**Town & Country Planning Act 1990 (as amended)
Town & country Planning (Development Management Procedure) (England) Order 2015
Application for Planning Permission for Works or Extension to a Dwelling**

Development Single storey rear & side extensions with internal alterations

Location 8 Well Road Pagham

I regret that I am unable to accept your documents as a formal application until the following item(s) have been received or resolved :-

Location Plan at 1:1250 scale

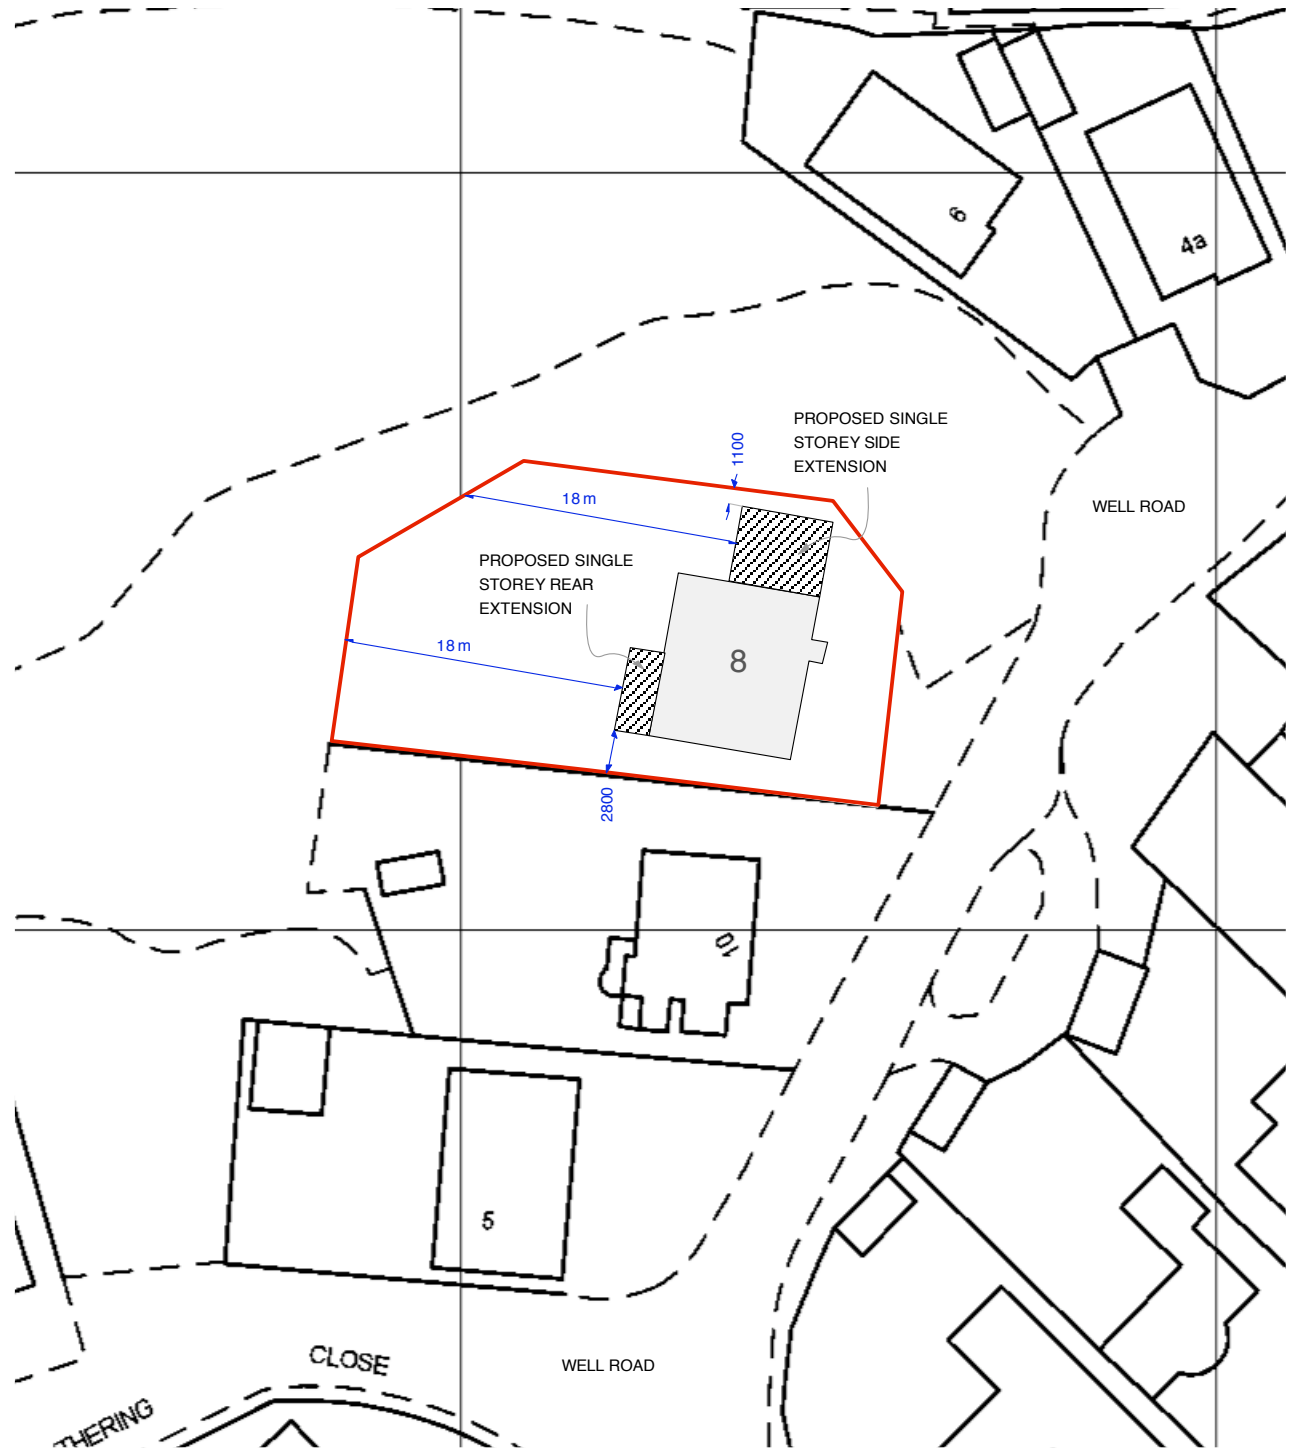
Unfortunatley the Location and Block plan have been sent to print at A1 and therefore the scales are incorrect, please therefore resend the Location and Block Plan accordingly.
